Re: Addison Galaxy FBO Civil Plan Review

Development: Galaxy FBO  
Town Project #: 19-09D  
Plan Review: 1<sup>st</sup> Civil Submittal

Summary of Engineering Review Comments

SHEET NUMBER
C03.02

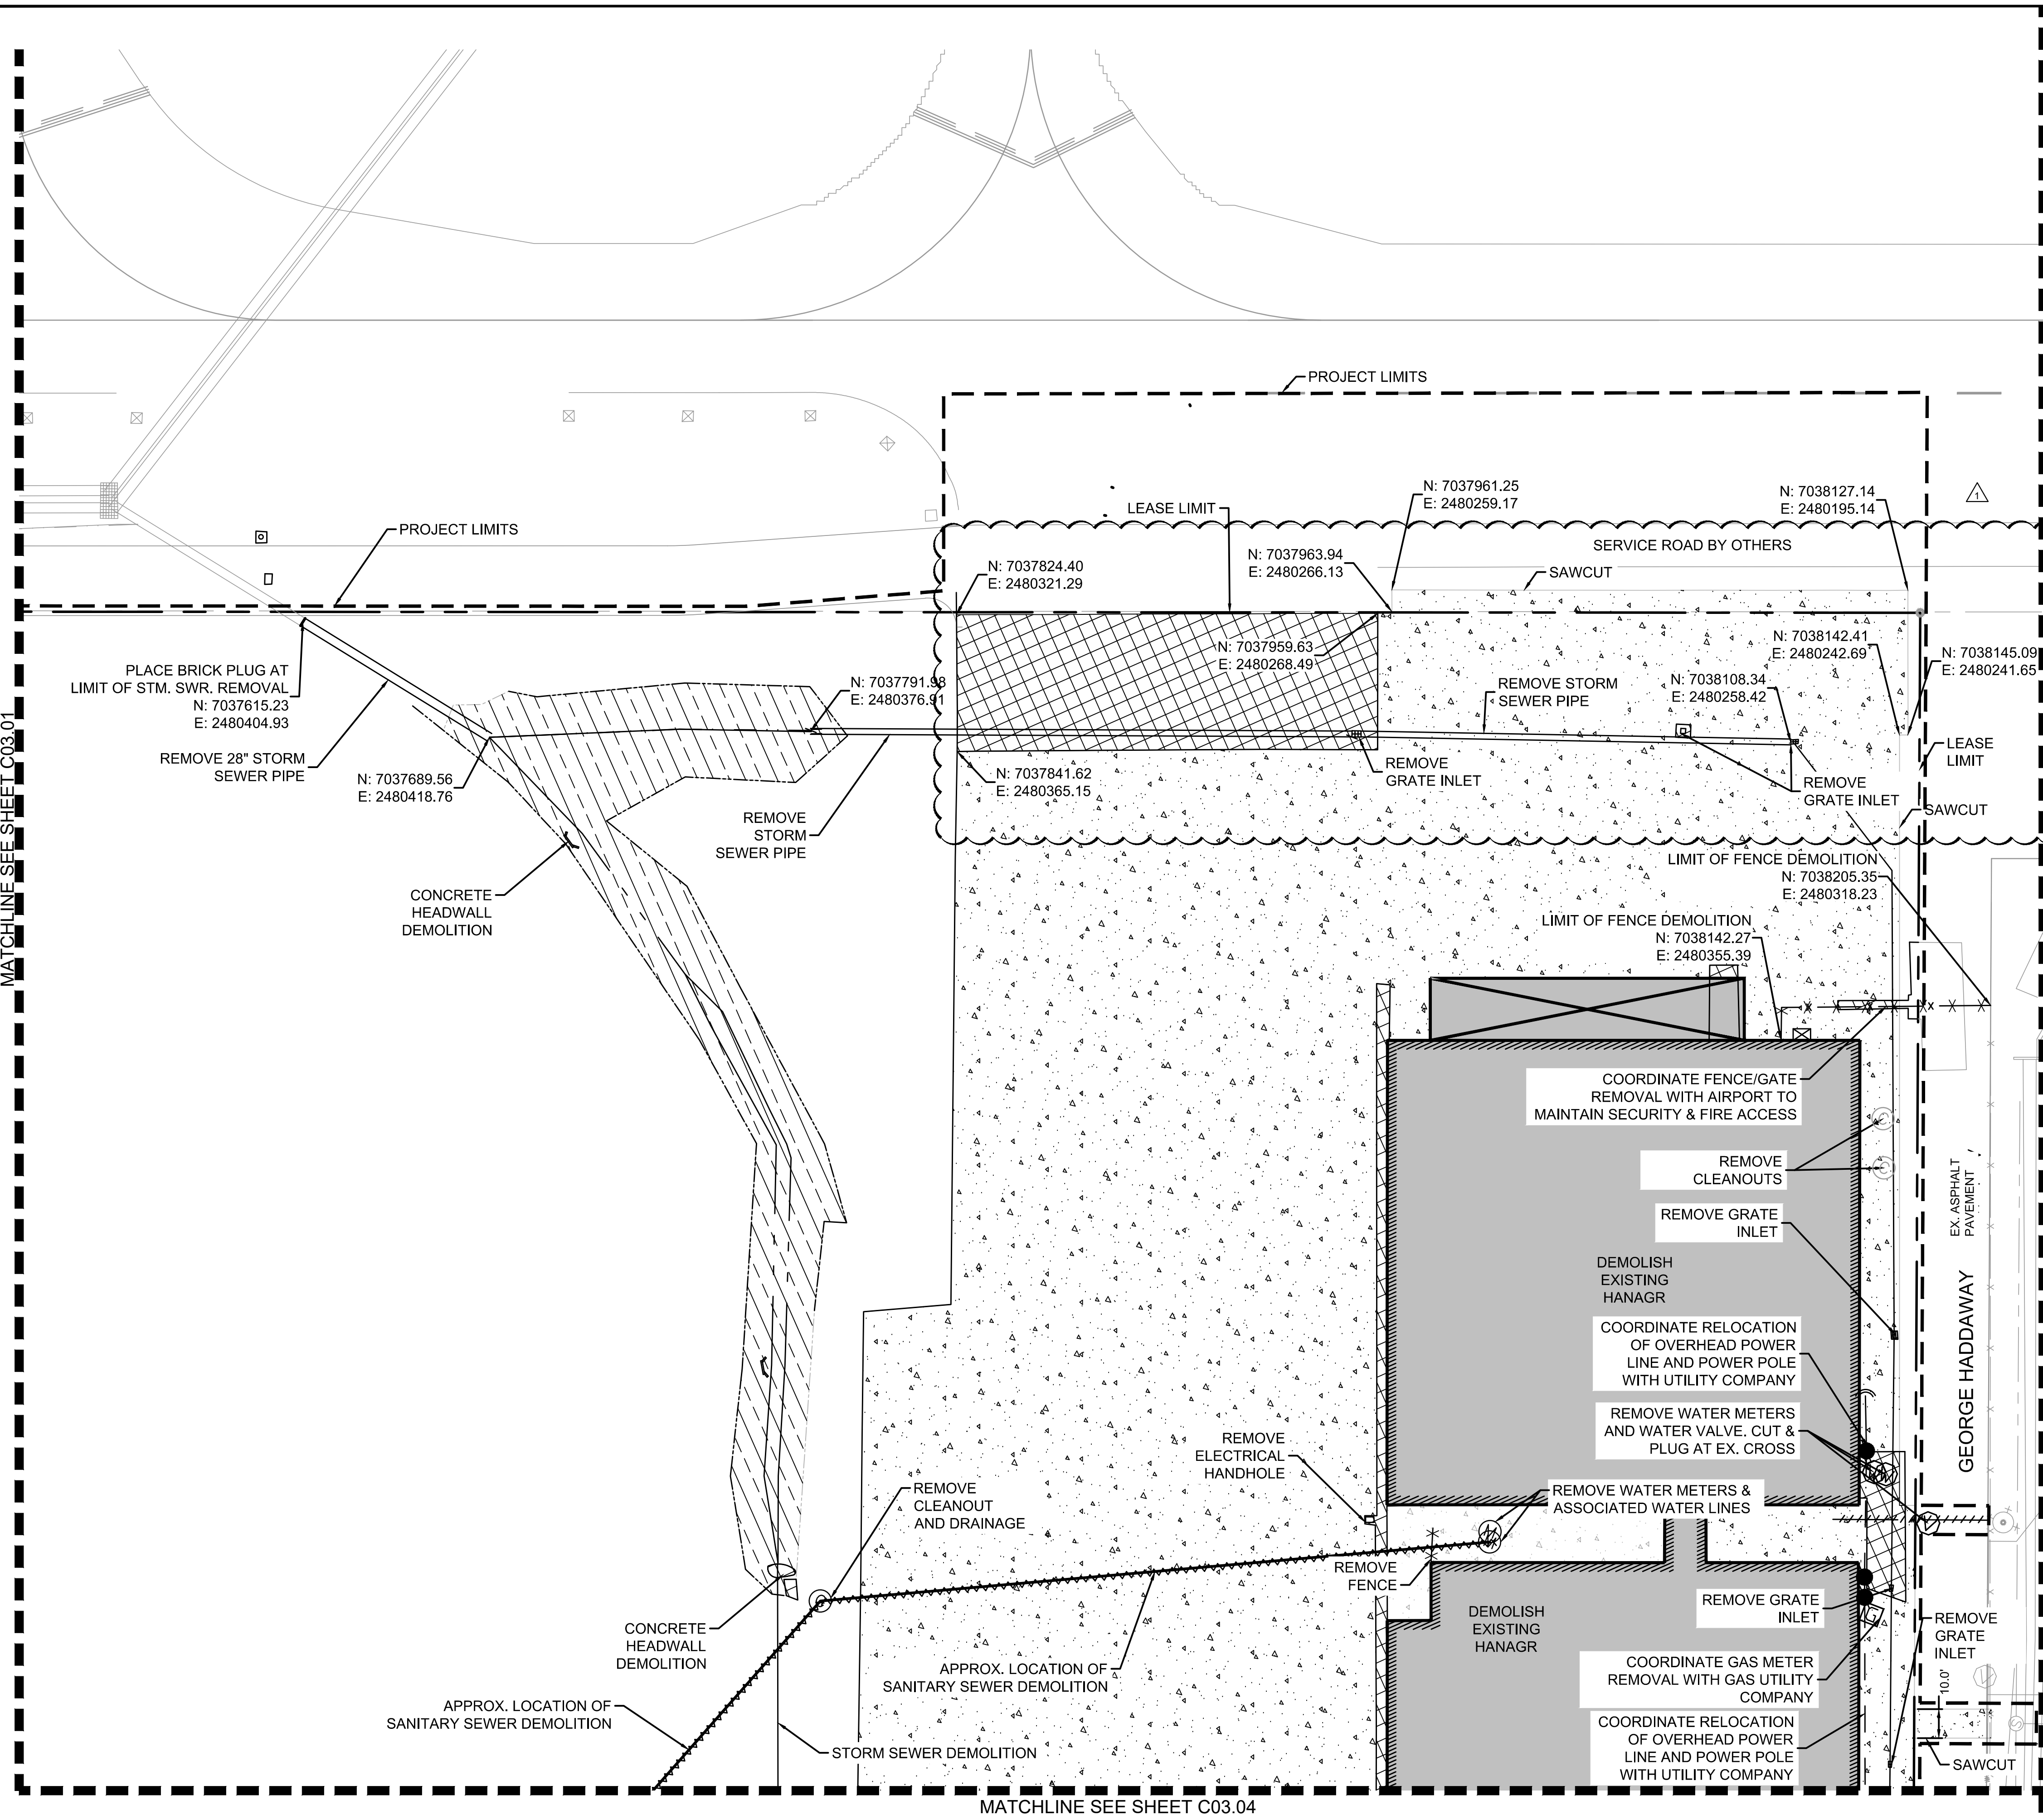
C03.01	Demo sidewalk to property line & connect back to ex.		
C03.02	Coordinate fence/gate removal with airport to maintain security & fire access.		
C03.02	Show ex. Sanitary service lines & cleanouts		
C03.02	Water should be cut & plugged at the cross.		
C03.03 & 03.04	Connect ex. Water line crossing Addison Rd to proposed line, demo ex line beyond extension point.		
C03.04	Show all existing drainage pipes across the site - coordinate with Dave Wilde to get records.		
C03.04	Remove tee on northern end of demo'd water line		
C04.01	Where is the new access road? Show location & connection to it.		
C04.03	Call for 1" expansion joint on details 3 & 5		
C05.01	Label all curb curve radii		
C05.01	Add detail nomenclature to the legend (typ)		
C05.01 & 05.05	Light duty pavement called out in the legend doesn't match the pavement detail. Should call for medium duty. (typ)		
C05.01	Transition sidewalk to match existing at the southern property line.

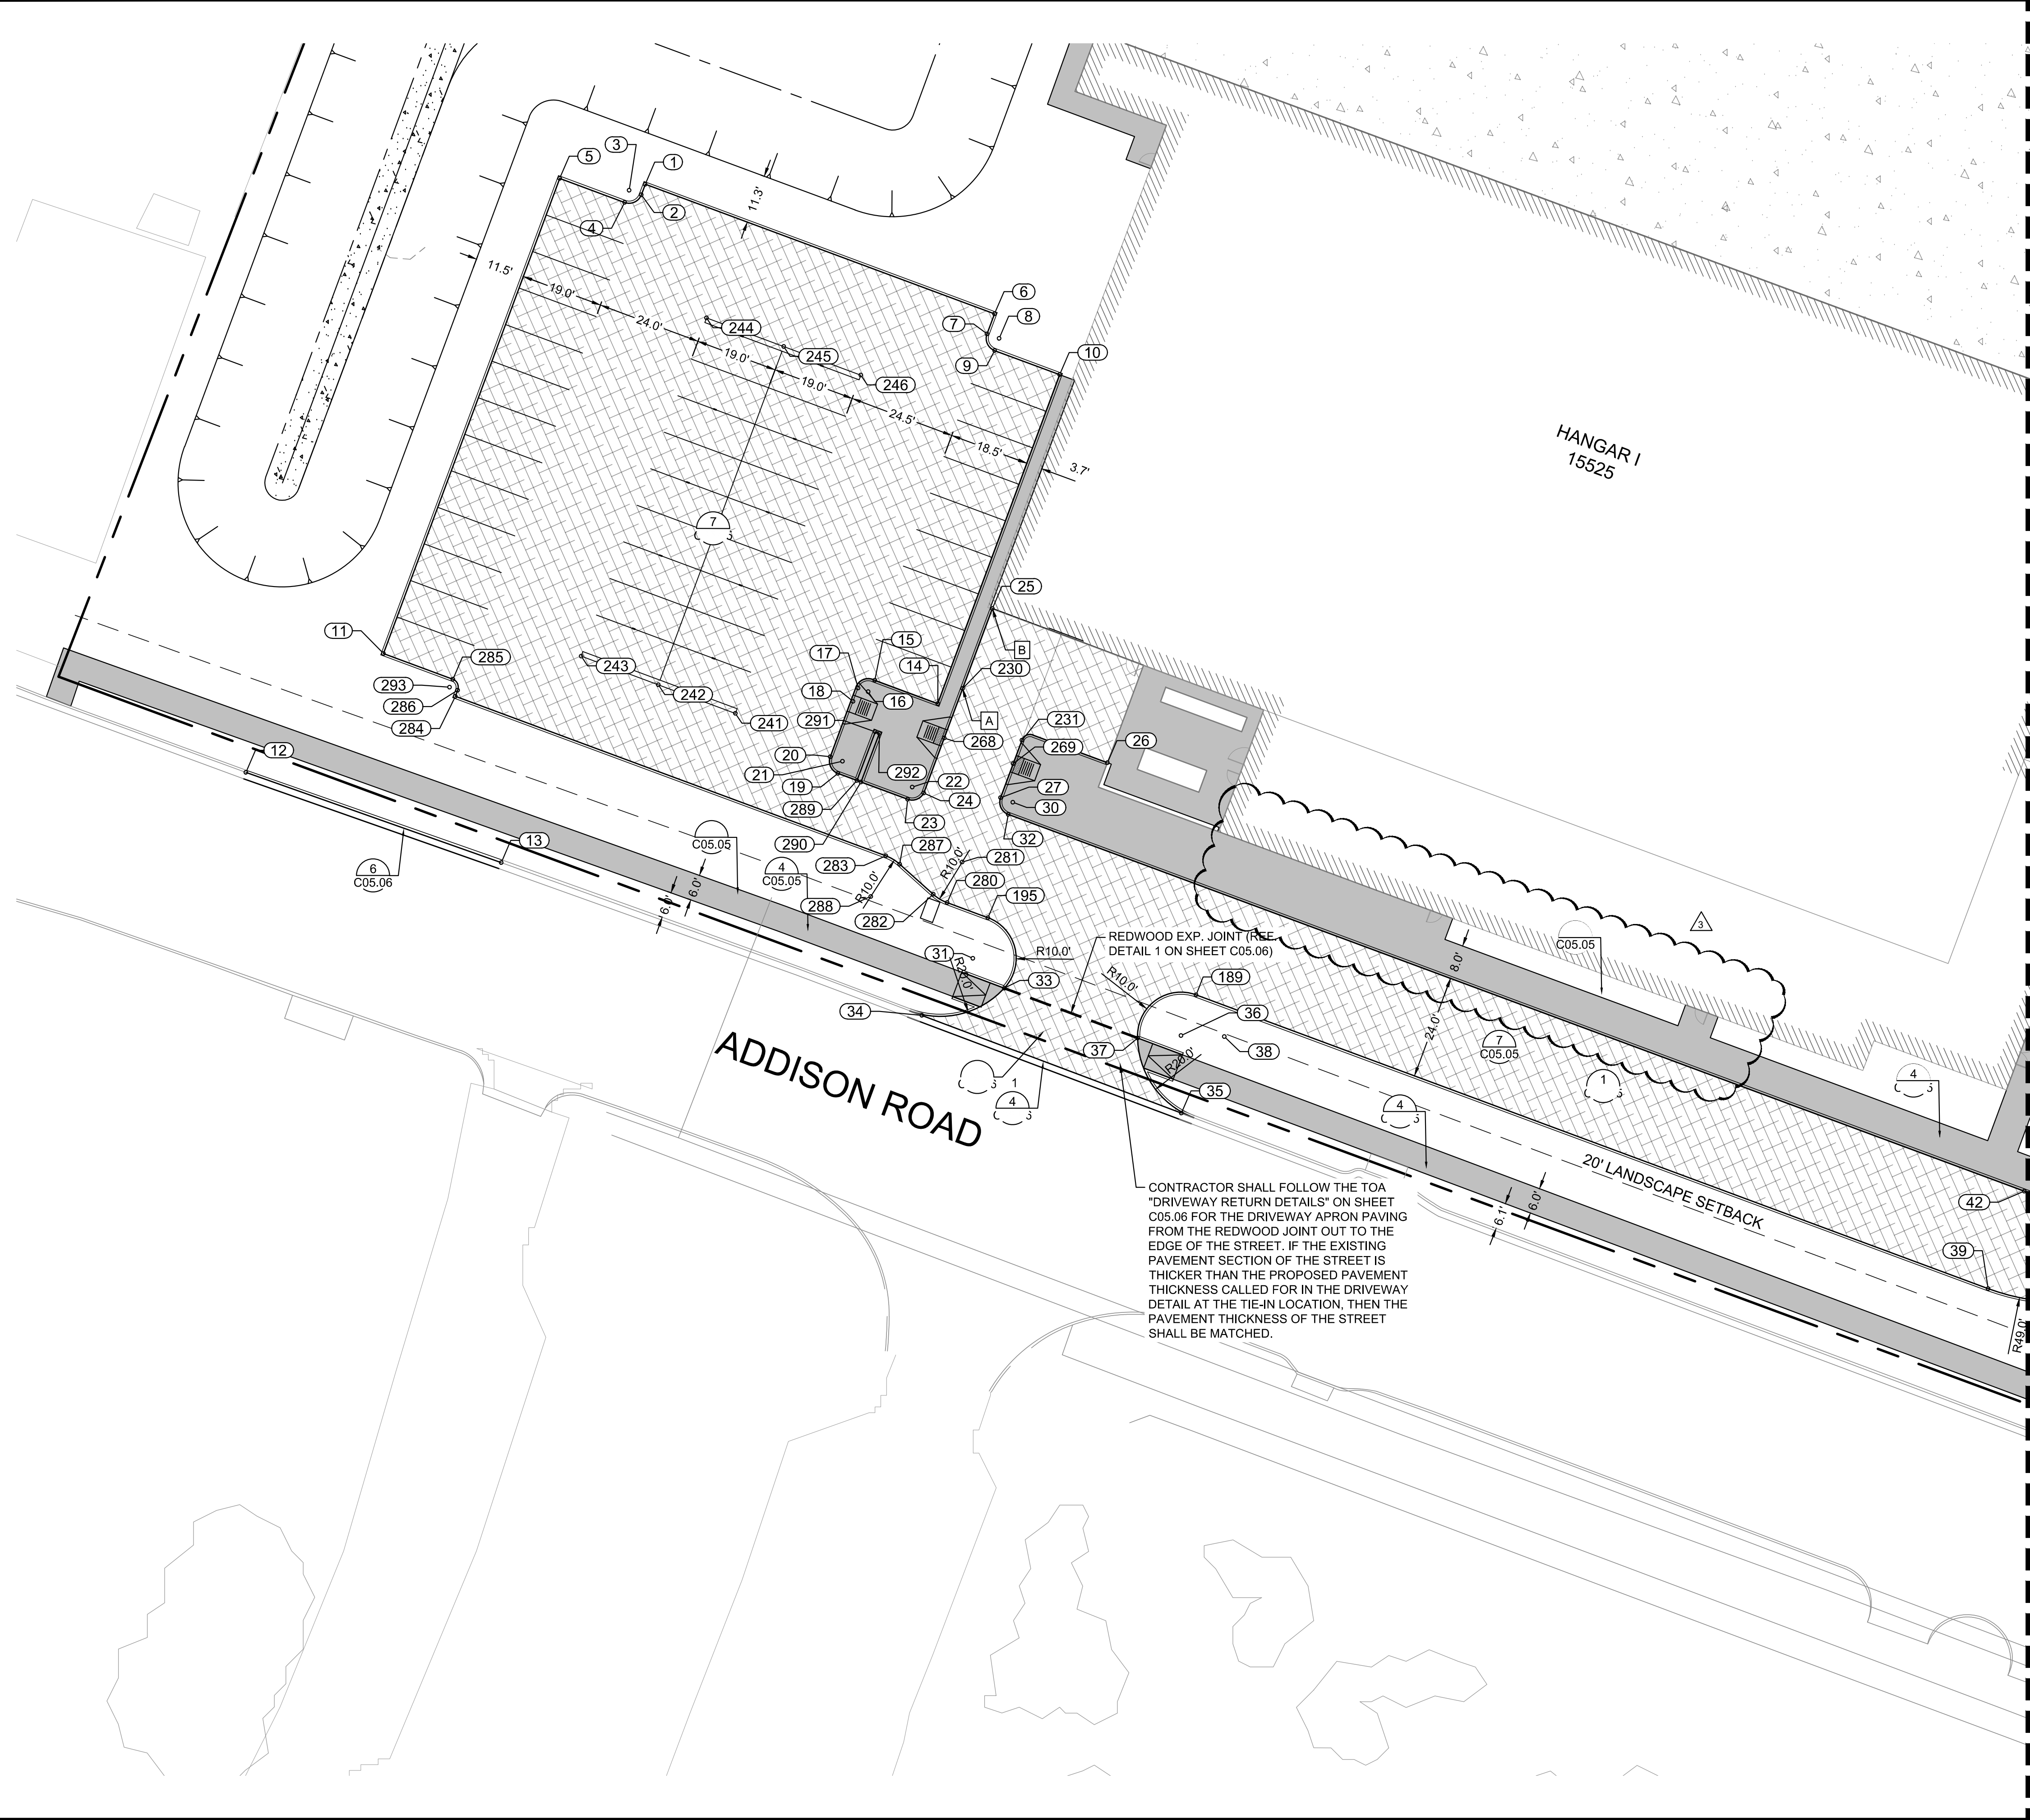
C05.01	Should be 5" sidewalk. (typ)		
C05.02	What is the darker cross-hatched area? It is not labeled or in the legend. If it is pedestrian accessible, it should have ramps.		
C05.02	Do you need a publicly accessible route from the street?
